Roxburgh McEwan Architects
Elizabeth Roxburgh
42 Forbes Road
Edinburgh
UK
EH10 4ED

Your Ref: 100657908-002
Our Ref: 24/00171/CAC

Application No: 24/00171/CAC
Proposal: Conservation area consent for substantial demolition
Address: 2 Westgate Crail Anstruther Fife KY10 3RF

NORTH ELEVATION  
1:100

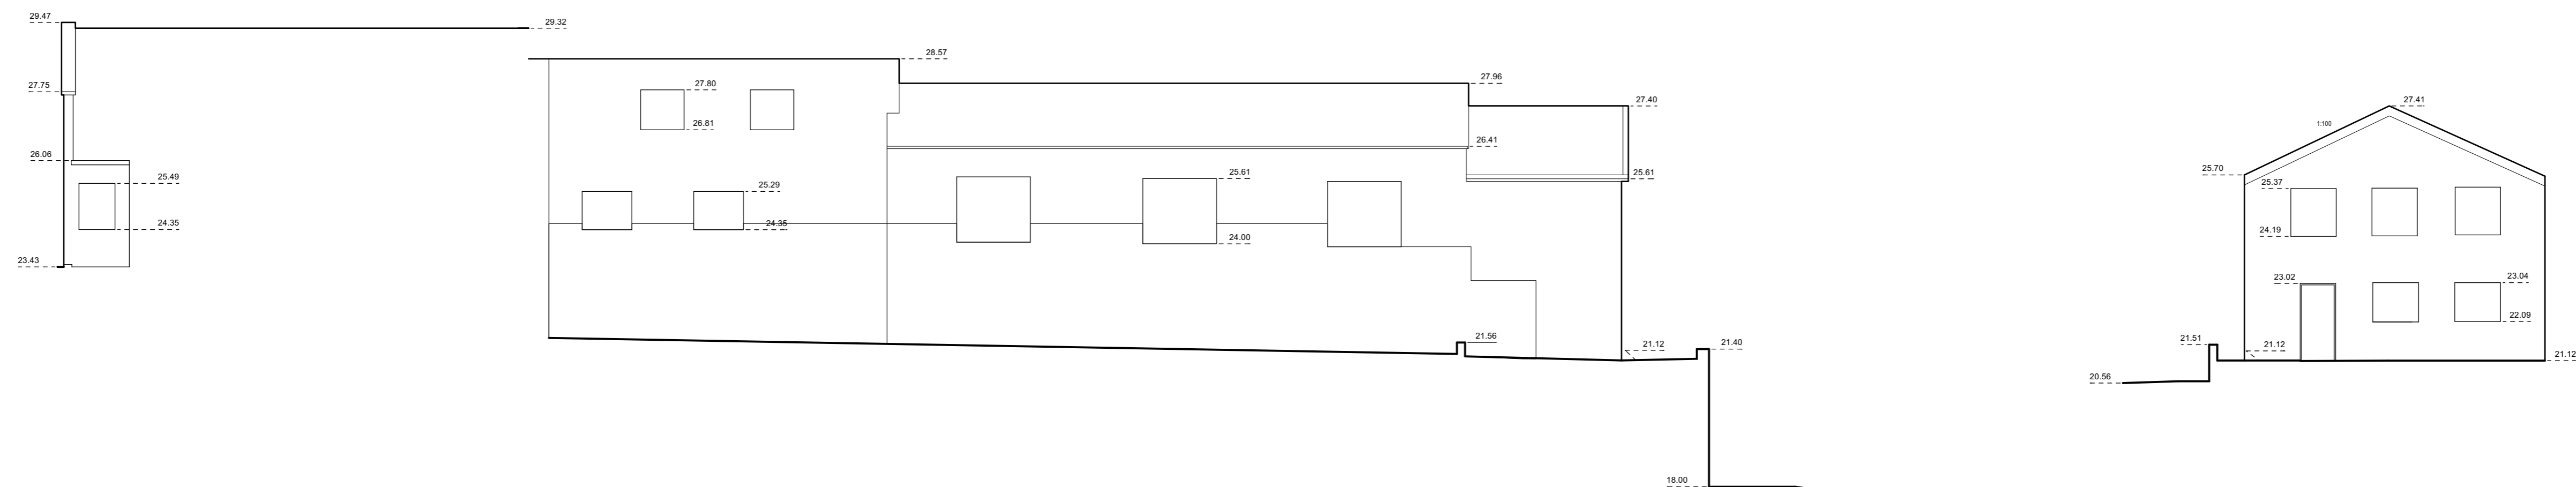
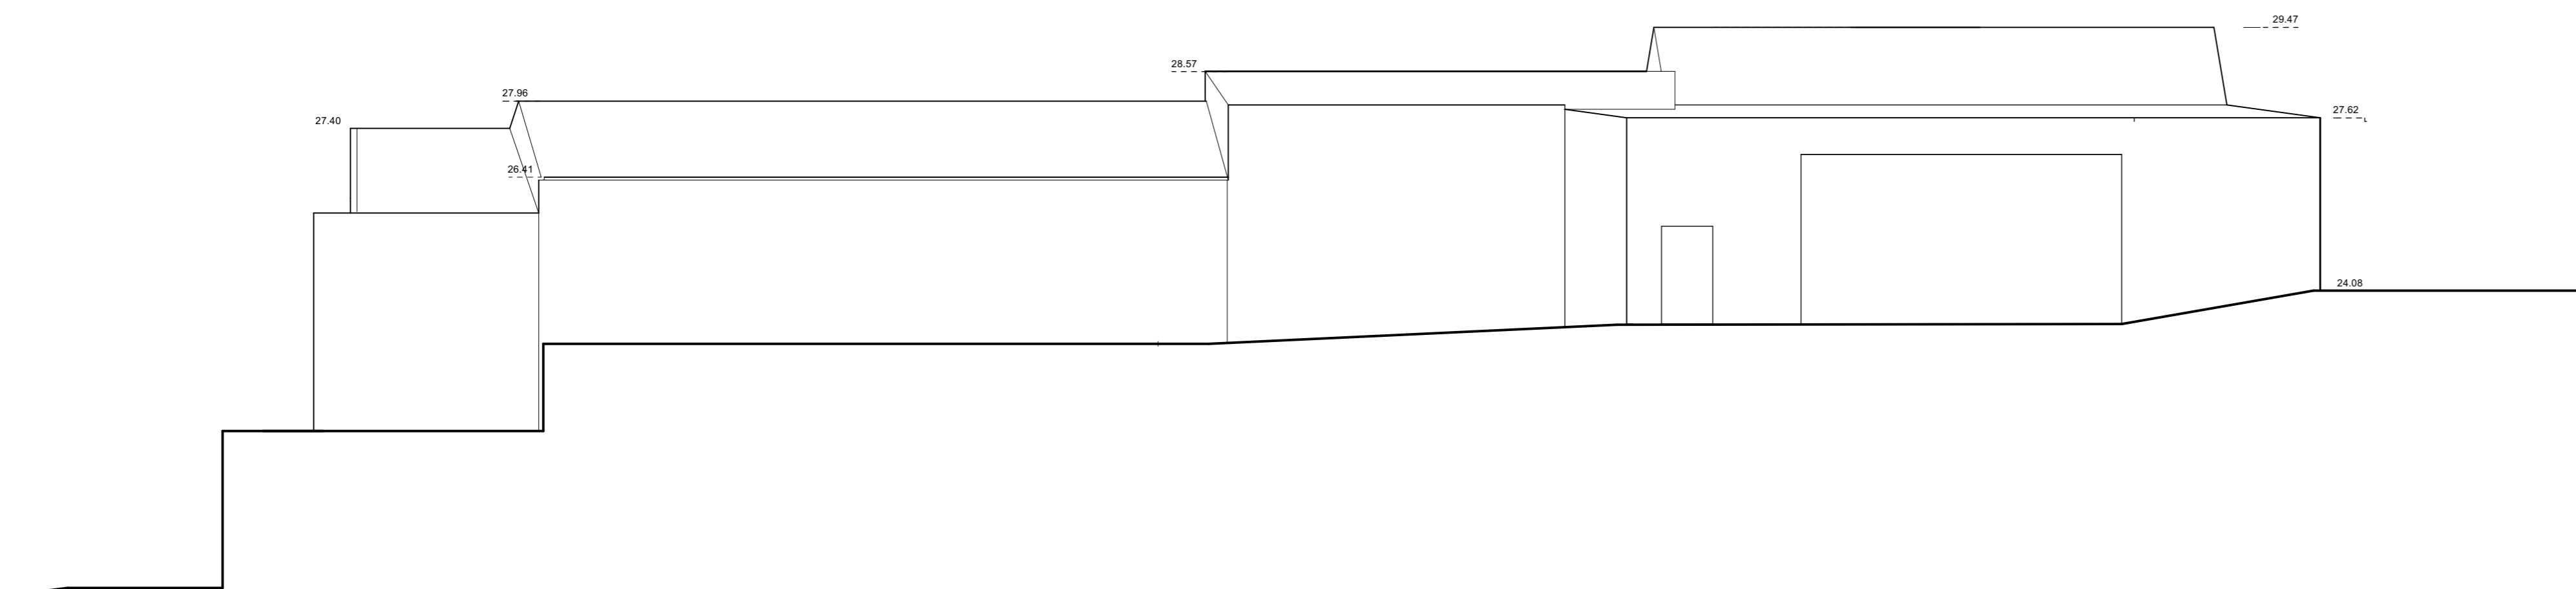
3. You have not submitted existing elevations to a scale of not less than 1:100.
4. Please provide photos of the existing structure to be demolished
5. To prevent unsightly gaps appearing in a conservation area, all demolitions should provide a supporting statement to cover the reasons for the demolition. At least one of the following;

LOCATION PLAN

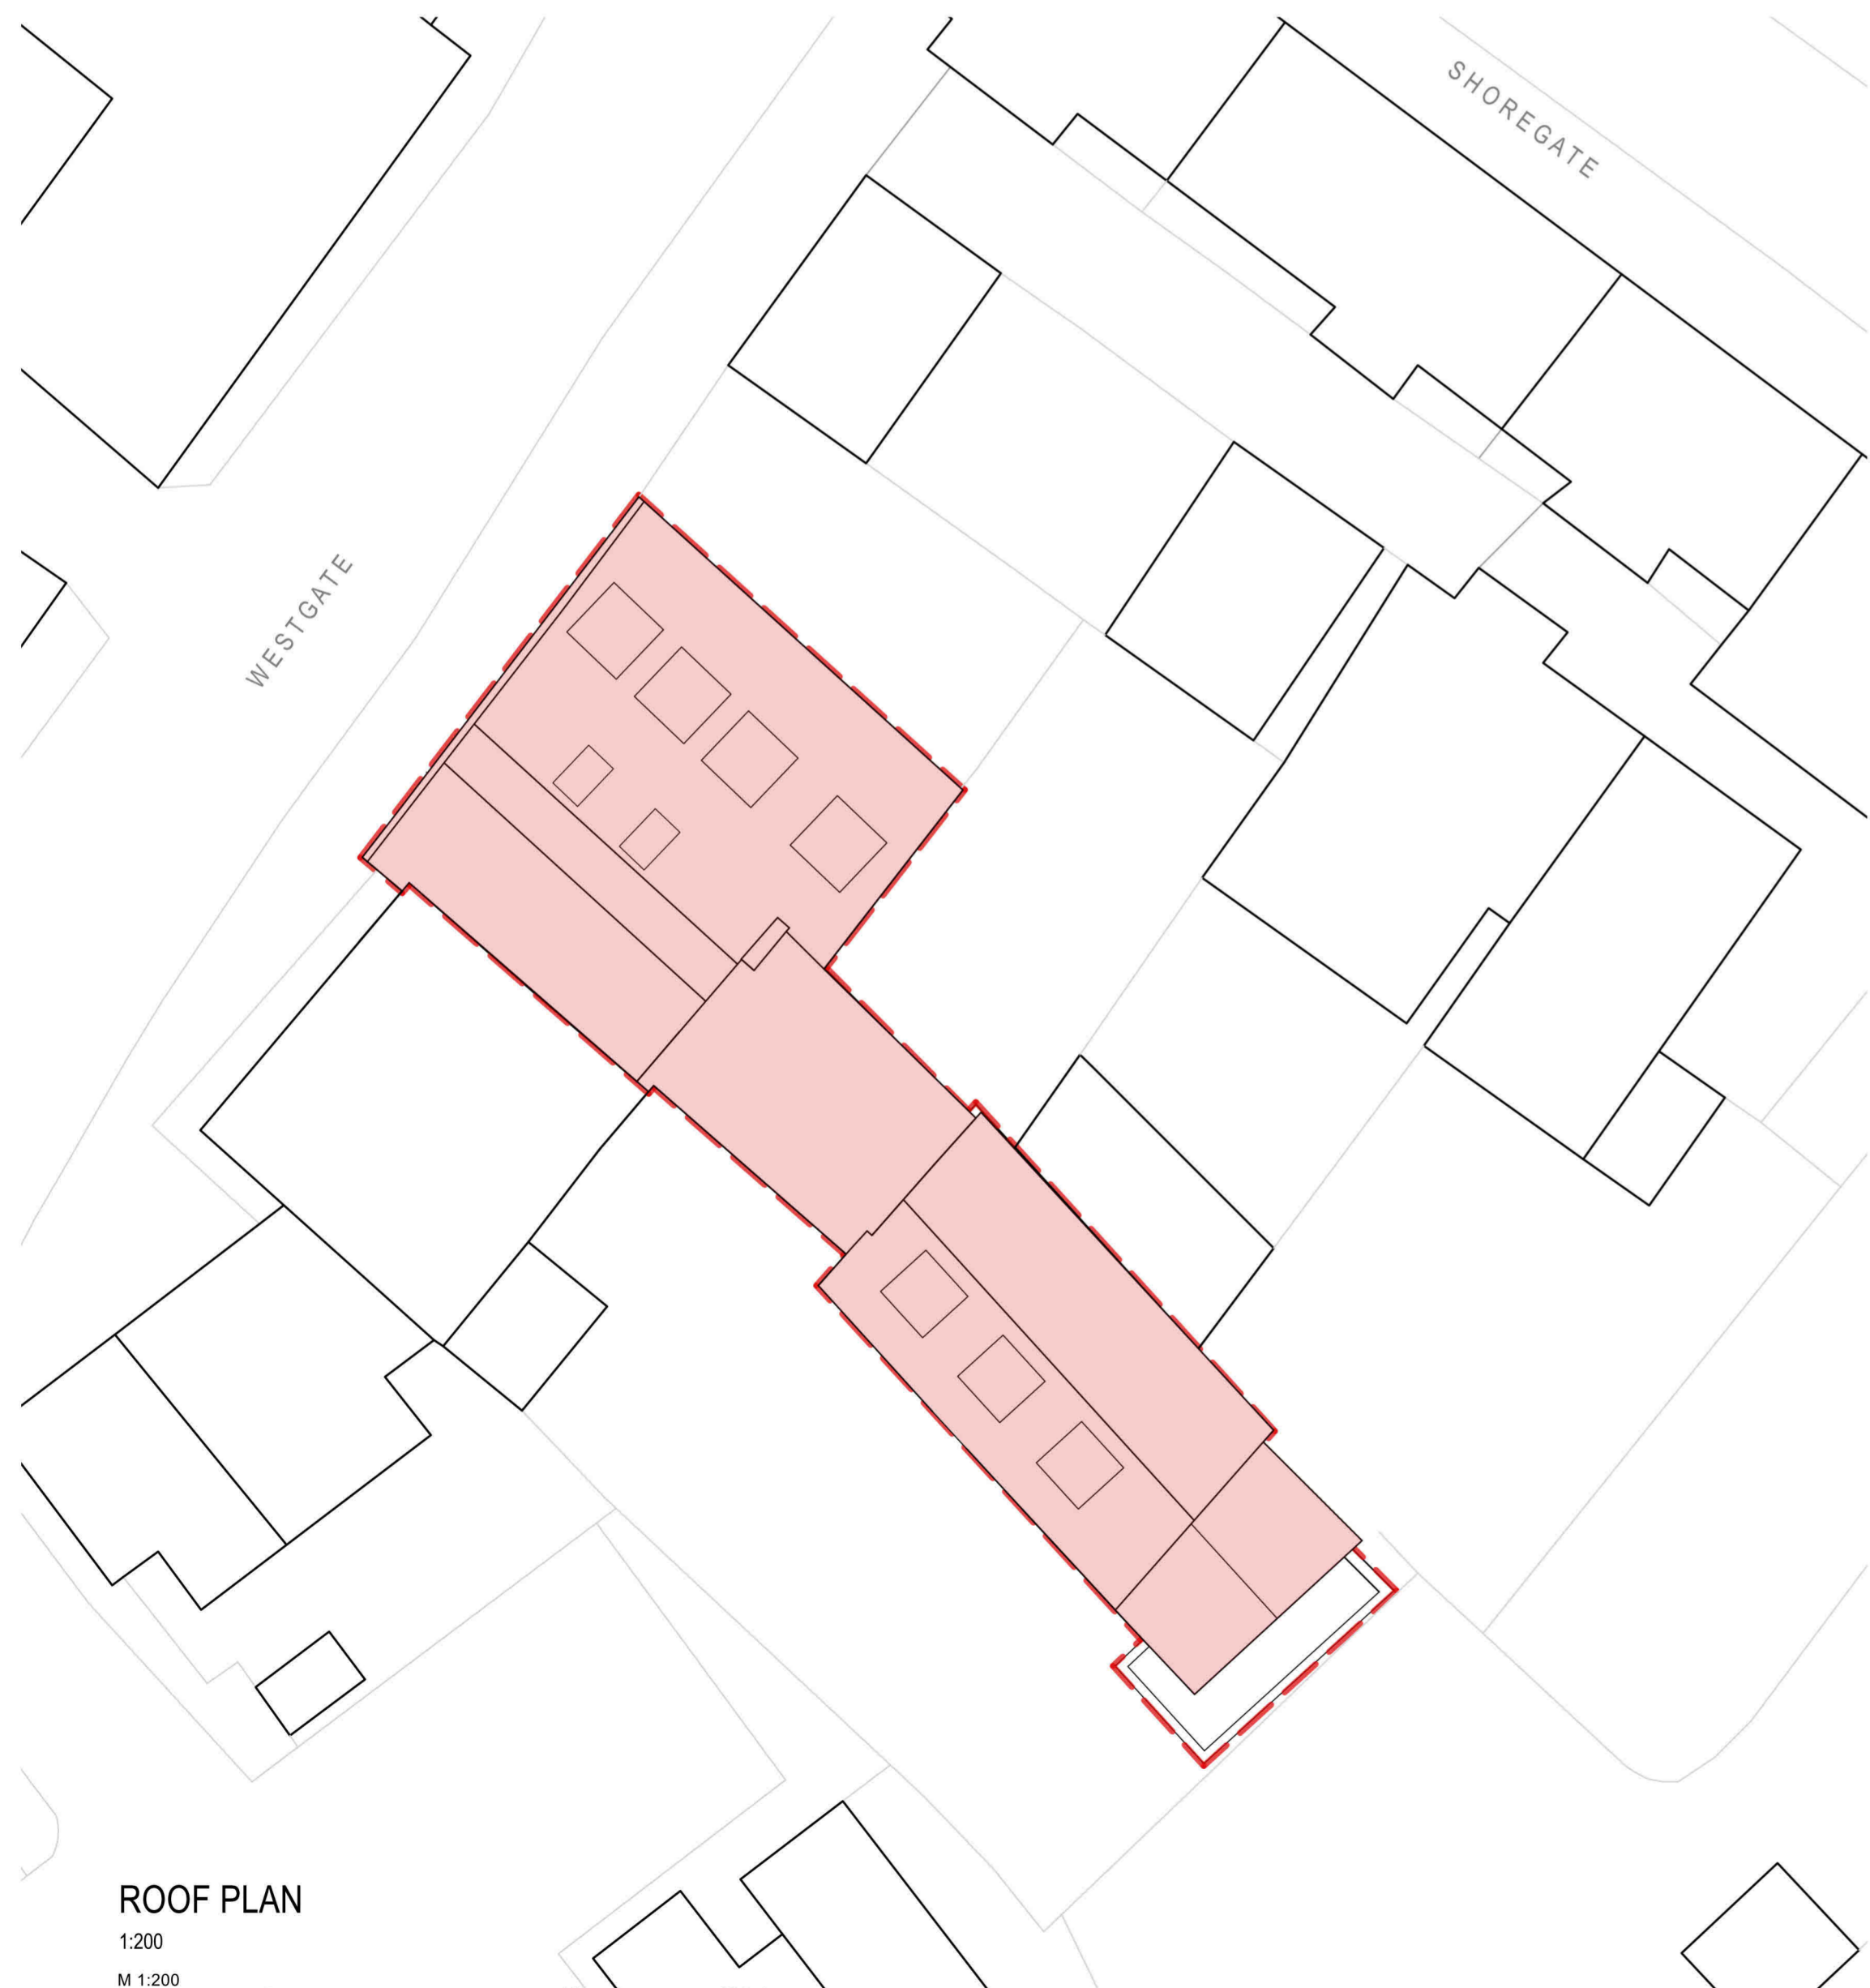
1. Please note that your location/block plan appears to breach Ordnance Survey copyright. You may wish to submit a location/block plan which contains an appropriate copyright acknowledgement and licence/serial number. If the plan is not derived from Ordnance Survey data, you are required to state the source of the plan.
